Please ask for: Sian Eggington
Email: sian.eggington@terraquest.co.uk
Telephone: 0121 2341390
Our Ref: R/174/20/PL
Your Ref:
Date: 17th September 2020

Application for Planning Permission

Development: Replacement windows and new patios.
Location: 11 & 14 Cleeves Court Cleeves Way Rustington BN16 3TS

Location Plan
1:1250 @ A3

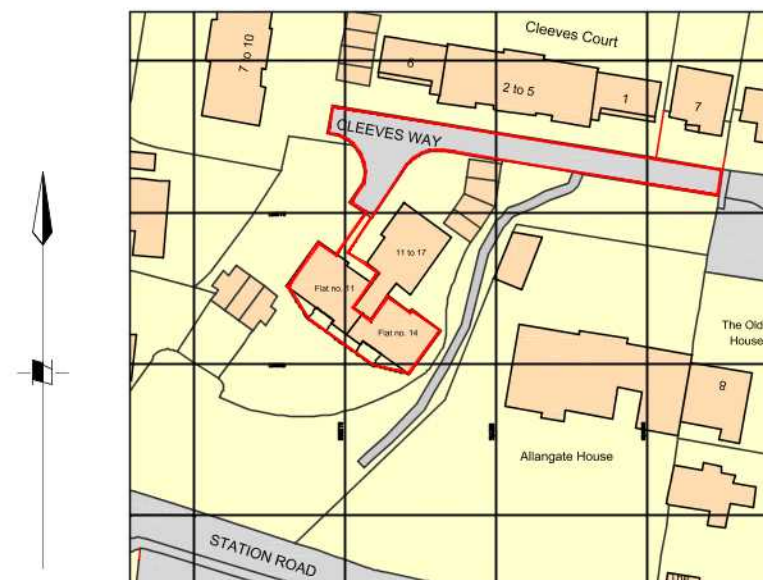
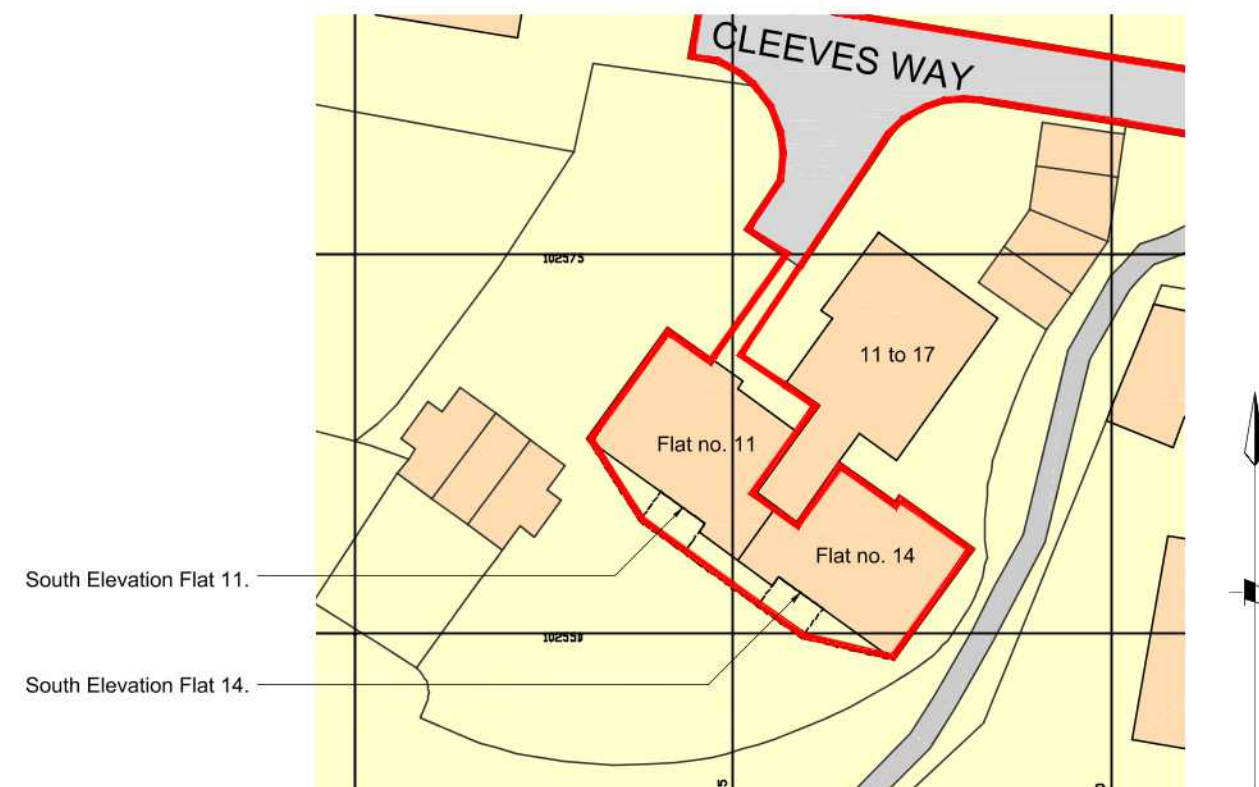
Location Plan: You are required to include the access within the red outline on the location plan
